WEST SUSSEX COUNTY COUNCIL CONSULTATION

TO:	Arun District Council FAO: Amber Willard
FROM:	WSCC - Highways Authority
DATE:	22 October 2019
LOCATION:	Greenock Villa Clyde Road Bognor Regis PO22 7AH
SUBJECT:	FP/213/19/HH Formation of new access together with dropped kerb crossover and formation of gravelled hardstanding.
DATE OF SITE VISIT:	n/a
RECOMMENDATION:	Advice
S106 CONTRIBUTION TOTAL:	n/a

Site Plan
Scale 1 : 200

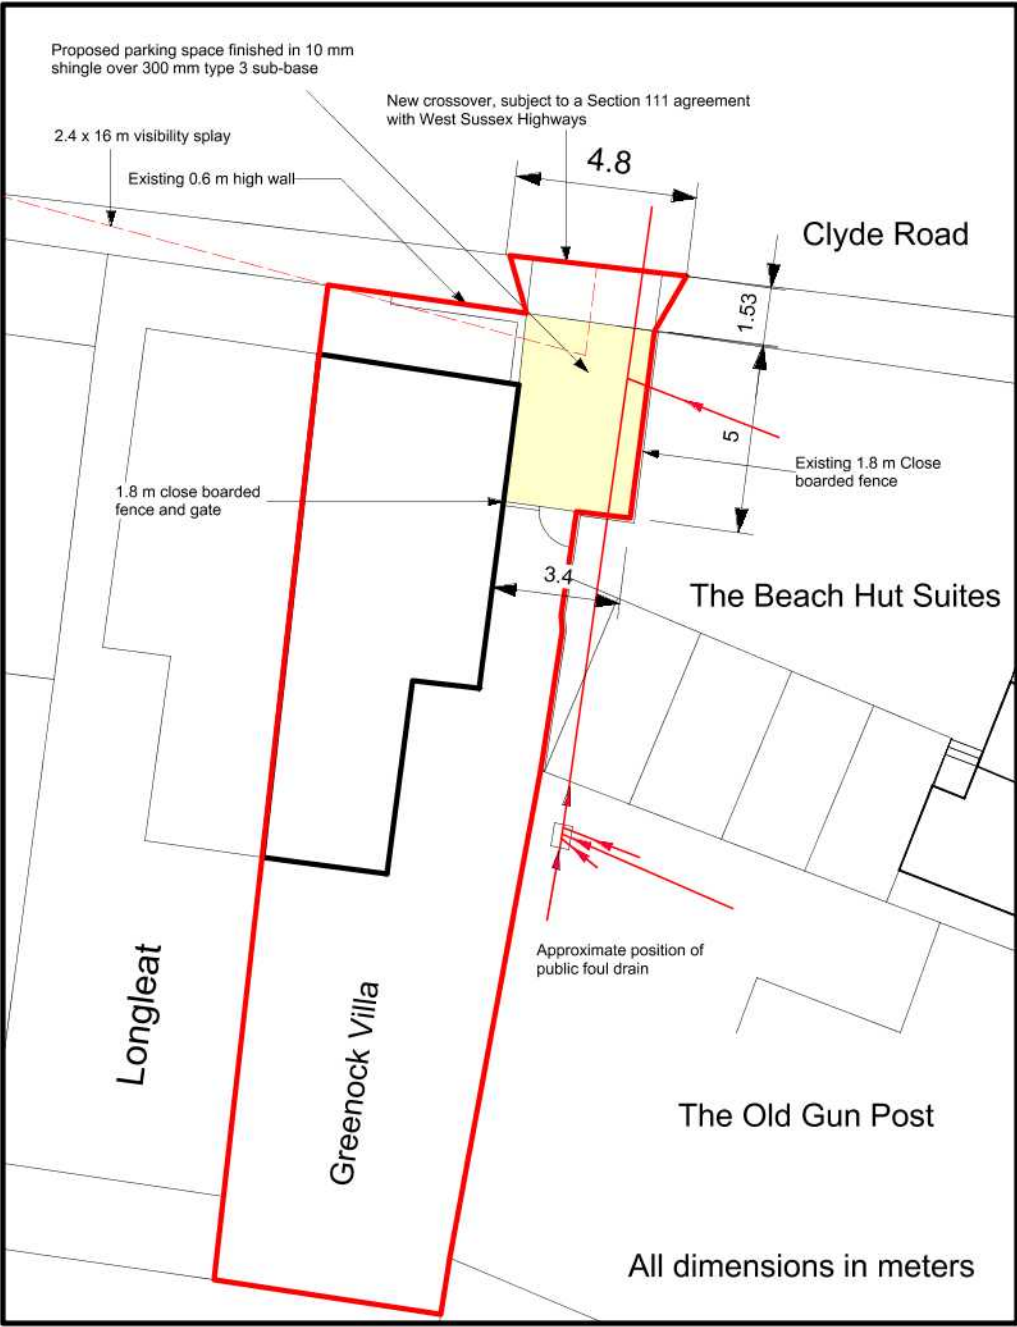
The applicant has proposed a new VCO (4.8 metres) in line with WSCC maximum width guidance of 6.4 metres.

To support this VCO the applicant has demonstrated visibility splays to the west of the access point of (Y) 16 by (X) 2.4 metres.

The applicant has failed to supply visibility splays to the east of the access, but due to the properties location in the cul-de-sac and inspection of WSCC local mapping, the Local Highways Authority (LHA) deem visibility acceptable in this direction.

Due to the quite/ lightly trafficked, low speed nature of the cul-de-sac and guidance from Manual for Streets (MfS), the LHA is minded to accept an X distance of 2 metres at the point of access. In doing so the maximum achievable visibility at the access increases slightly to a Y measurement of 24 metres with an offset of 1 metre (representation of

actual vehicles driving position on the highway) from the kerb. The LHA is minded to accept that suitable visibility splays can be provided using only highways land.

The applicant has demonstrated a parking area within the minimum requirements set out by MfS and WSCC Guidance (2.4 x 4.8 metres single bay) with measurements of 3.3 x 4.9 metres. This will give the applicant the ability to remove one car off the road in this location that would otherwise park on street narrowing the highway.

The proposed drive is to be constructed from gravel. If the Local Planning Authority (LPA) is minded to permit this development then the LHA ask the applicant to make sure during the design stage of the access, that a 'granite set' type line separates the applicants land from the publicly maintained highway. This should help aid in the applicant keeping the access point free of materials.

The use of the parking area shall not commence until the vehicular access serving the development has been constructed in accordance with the approved site plan.

The use of the access shall not commence until such time as the parking area has been constructed in accordance with the approved site plans. These spaces shall thereafter be retained at all times for their designated purpose.
